**MONUMENT FIRE DISTRICT**

Subject: Monument Glamping II, AL Special Use

Date: March 11, 2024

SITE PLAN

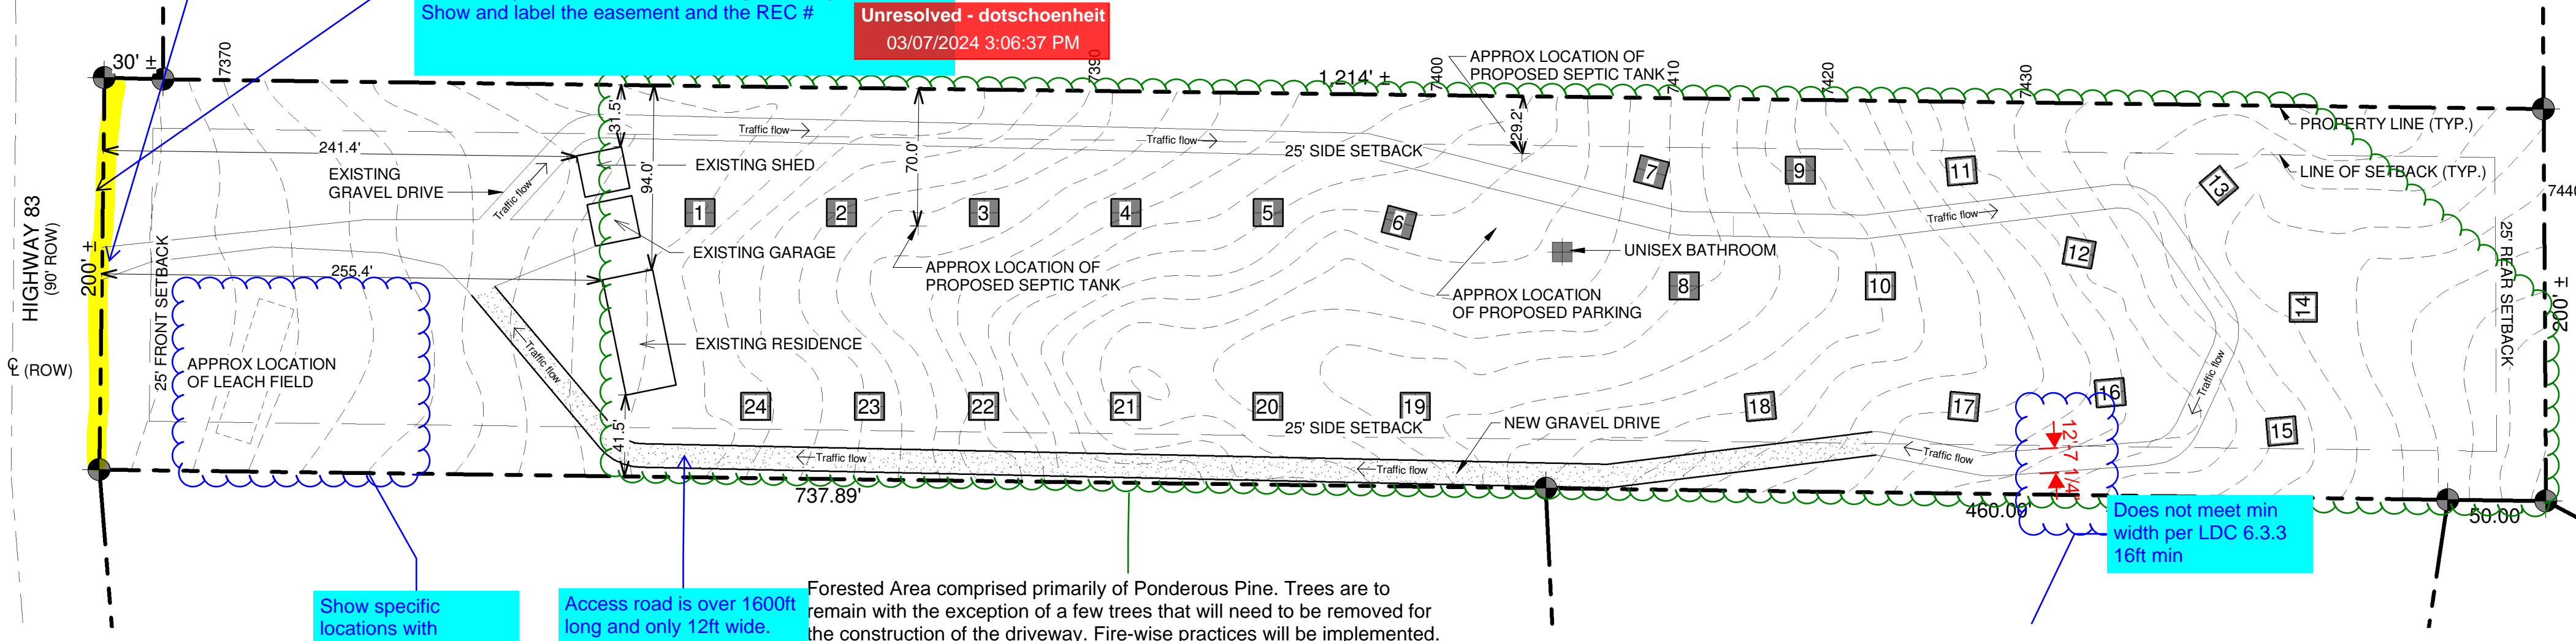
- The width of the access driveway comment from the PCD Project Manager suggests increasing the width from 12 feet to 16 feet. The LDC 6.3.3 states 16 feet is the minimum driveway width. For this project the fire department requires an access road/driveway width of 20 feet.

- Based on the road length in excess of 1400 feet the fire department requires at least one and preferably two turnarounds that meet the specifications of the adopted 2015 Fire Code and local amendments for FD access as listed in Appendix D.

- The free flow of traffic on a one-way drive for public egress/evacuation and emergency vehicle ingress and operations is required. The current driveway width is not sufficient.

- The length of the driveway necessitates turnarounds for public traffic to avoid an emergency scene and for emergency traffic to efficiently access and operate on an emergency scene. One turnaround is required and two are recommended at roughly the midpoint of the driveway on the north and south sides of the property.

- The fire department requirements are:
  - Access road/driveway increased from 12-20 feet.
  - Turnaround meeting the requirements of 2015 Fire Code and local amendments for FD access as listed in Appendix D. Suggested locations are between lot 18 and 19, or lot 13 and 14.
